**To:** Lopez, Anthony C.  
**Cc:** Billy McCarty (beamdesigns@qwest.net)  
**Subject:** FW: Corrected Bricklight Alley Final Inspection (CPN 509182)

**Re: Bricklight Courtyards, Lots 6-10 & 17-21, 115 Harvard SE Bldgs. A-D**  
**request for Permanent Certificate of Occupancy (C.O.)**  
**Engineer's Stamp dated 6/06/07 (K-16/D005)**  
**Certification dated 7/08/08**

**Re: Bricklight Courtyards, Lots 6-10 & 17-21,  
Reject of Request for Permanent Certificate of Occupancy (C.O.)  
Engineer's Stamp dated 6/06/07 (K-16/D005)  
Certification dated 7/01/08**

project file
Bricklight Courtyards
Lots 6-10, 17-21, University Heights
Albuquerque, New Mexico
sheet
C003

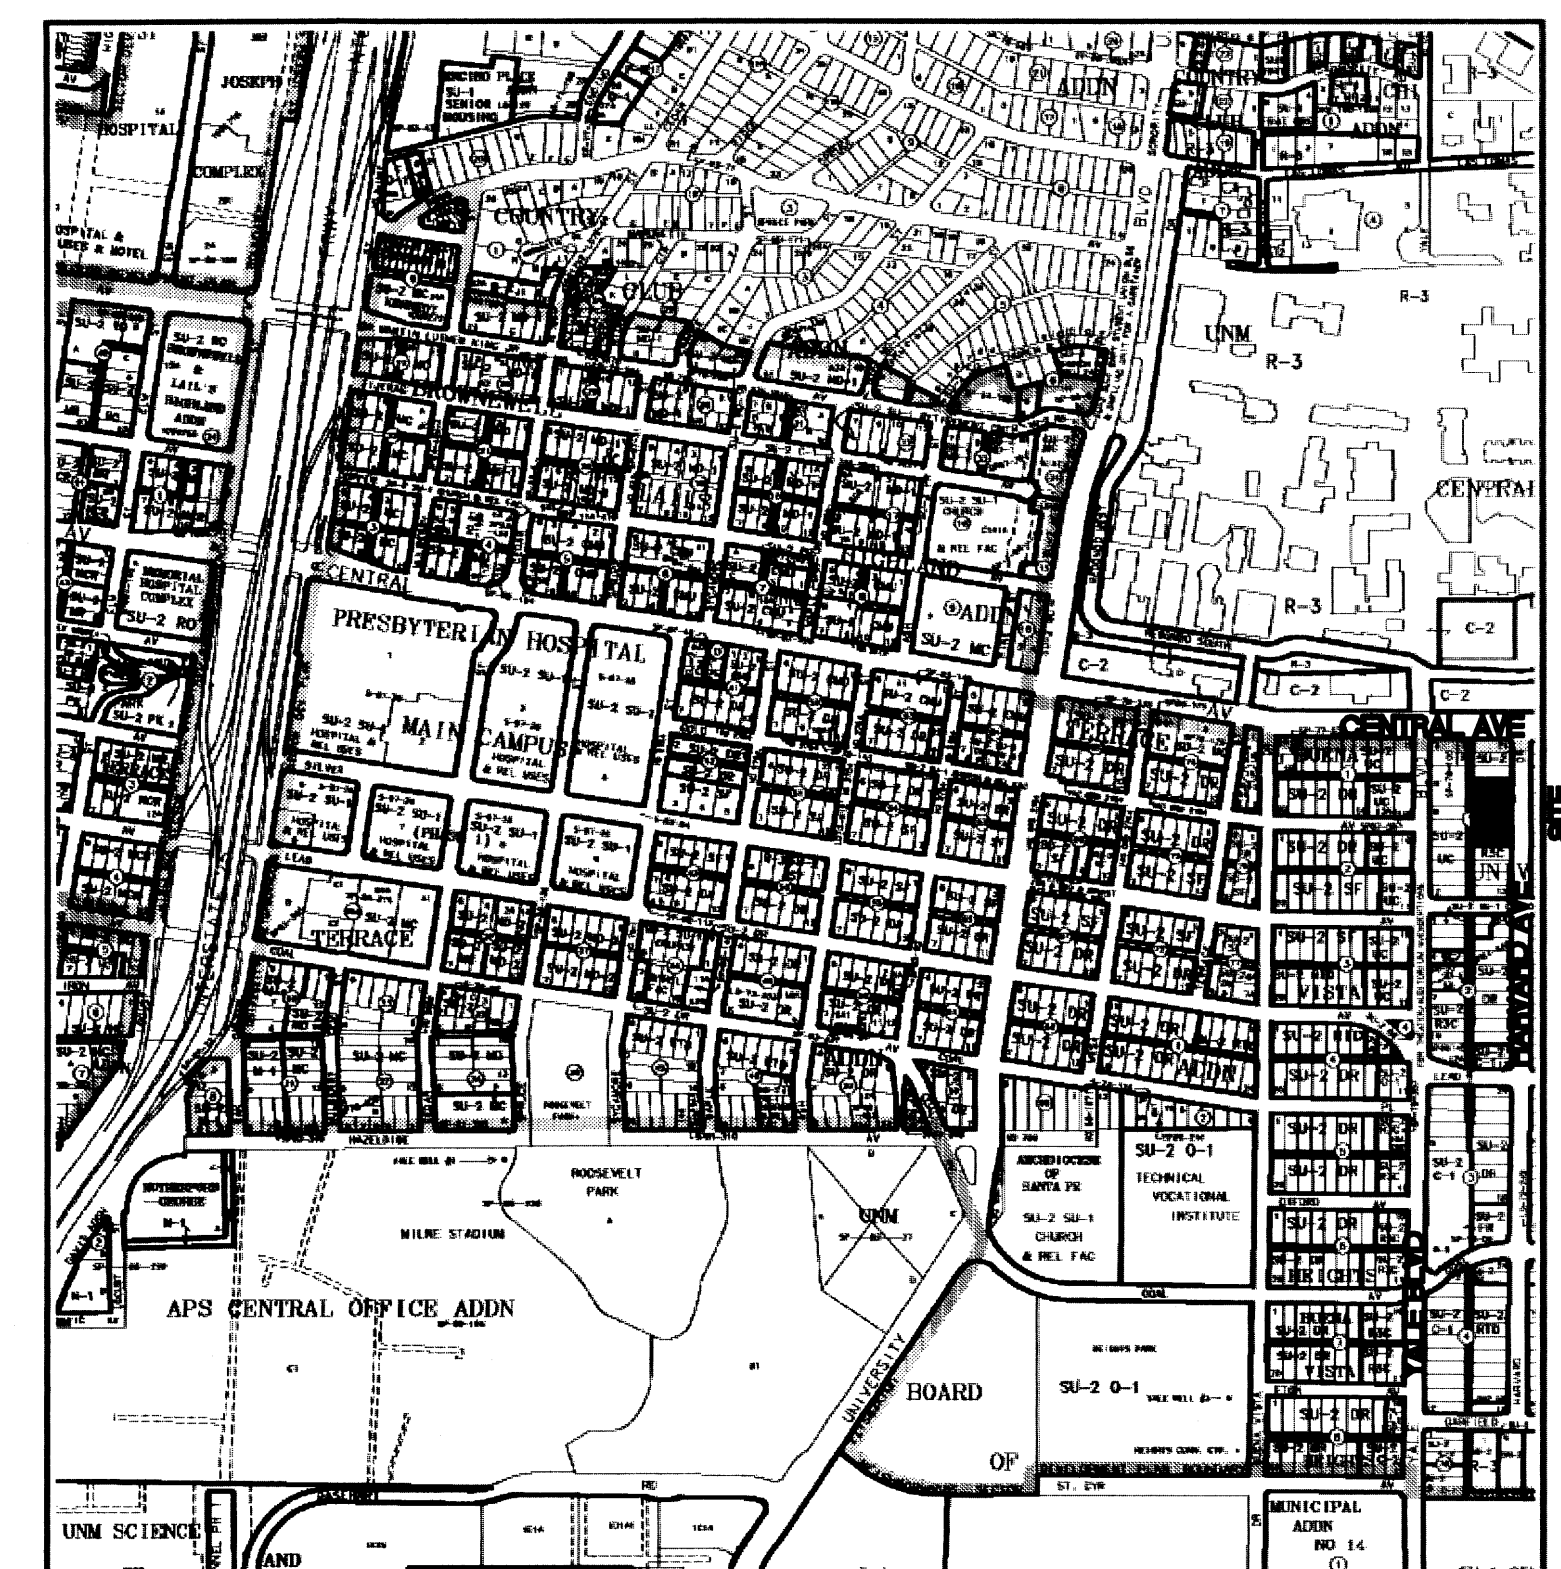
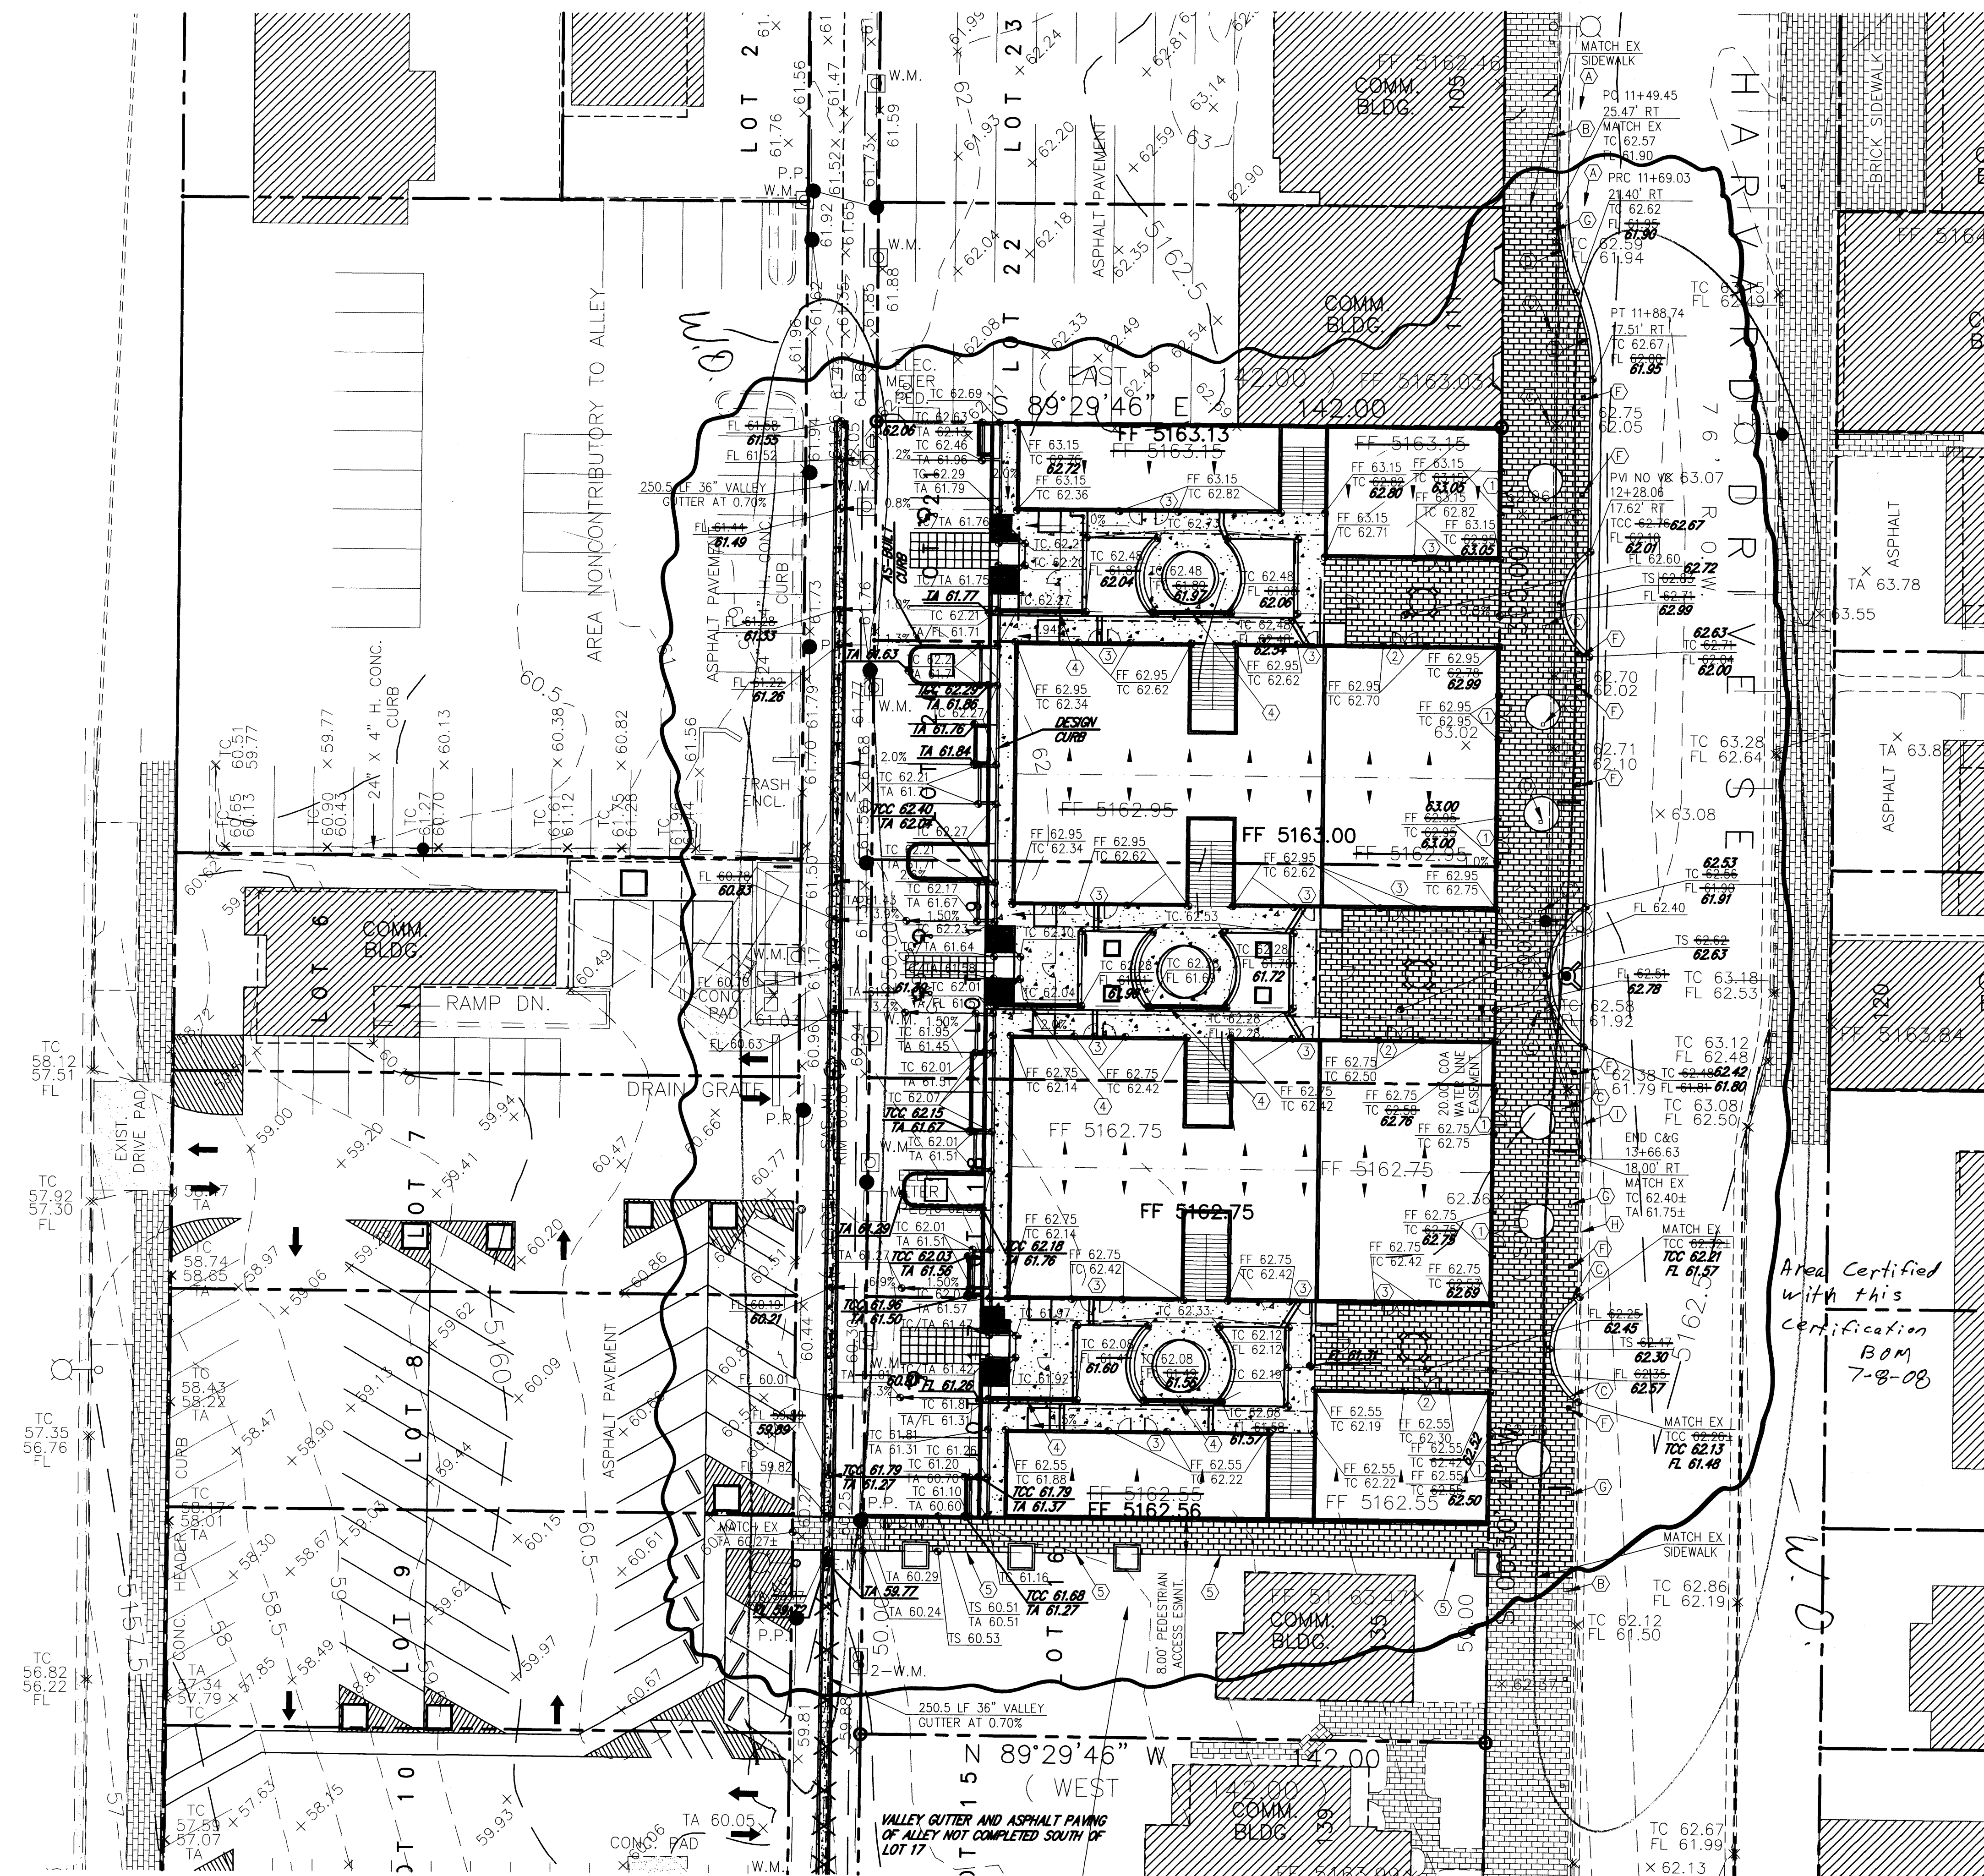
1. Specify the building addresses that are to be certified with this submittal.
2. Which area are you certifying? Please cloud or indicate which portion is to be certified. Is lots 6-10 a part of this certification; if so, what are the as constructed elevations in this area?
